M25 Junction 10 Project Team  
National Infrastructure Planning  
The Planning Inspectorate  
Temple Quay House  
2 The Square  
Bristol  
BS1 6PN  
M25Junction10@planninginspectorate.go.uk

M25 junction 10/A3 Wisley interchange improvement scheme Targeted non-statutory consultation -  
Deadline 6, April 04 2020, Post hearing submissions including written submissions of oral case

Change 2 – Incorporation of two toad underpasses at Old Lane and other mitigation measures

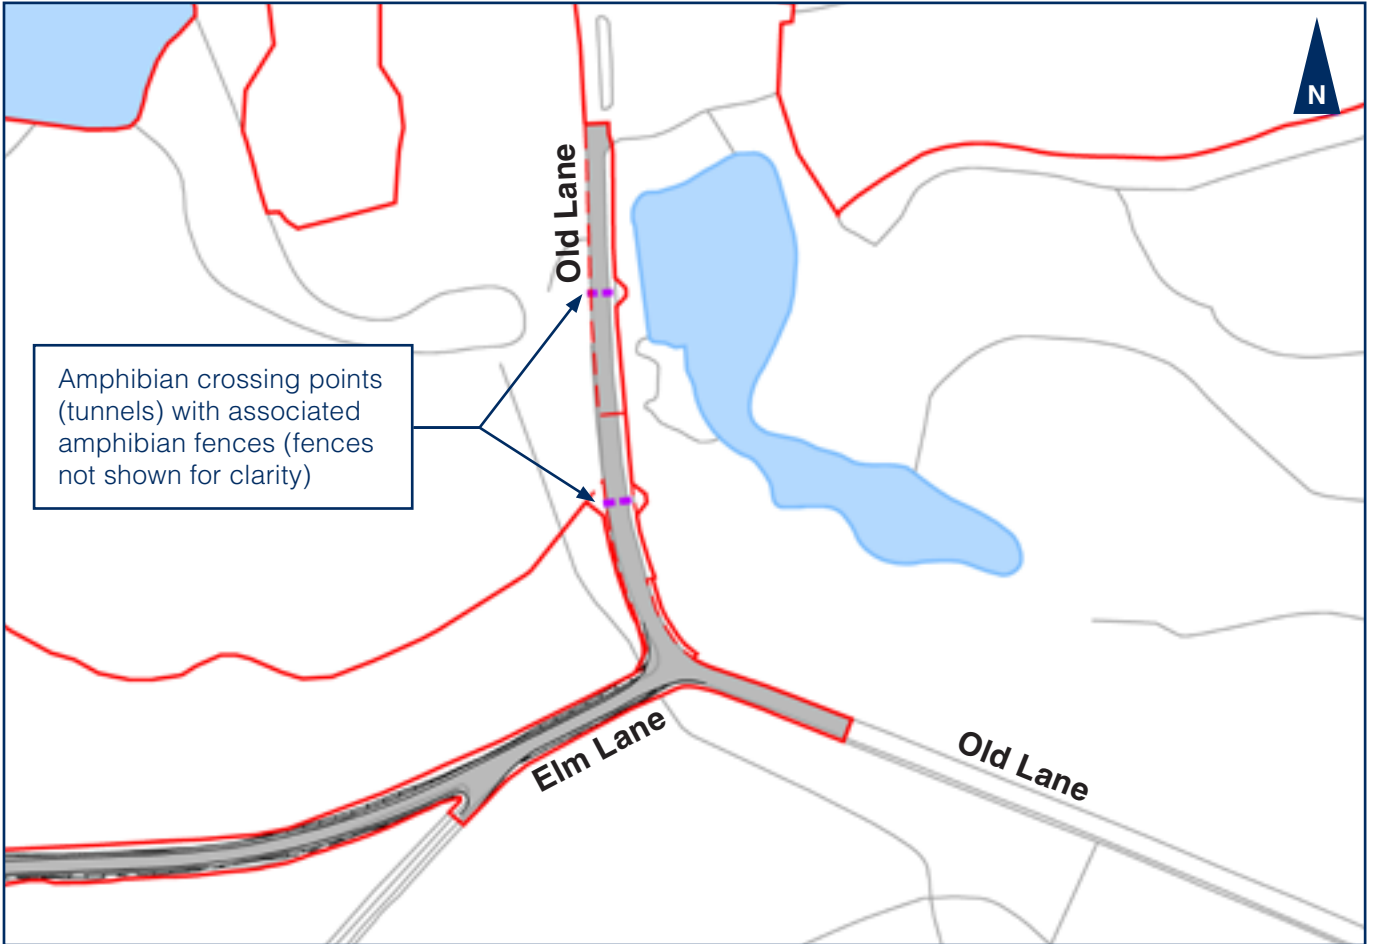
I am very worried to have been told that HE intend to NOT increase the number of amphibian tunnels in Old Lane, nor to install toad tunnels in the new Elm Lane. I do very much hope that this is not final and that HE will do more to mitigate for toad mortality.

I feel that only point 3) of the above is currently being addressed by Change 2 to the dDCO.

More needs to be done to ensure that all the above impacts are properly assessed and adequately mitigated for.
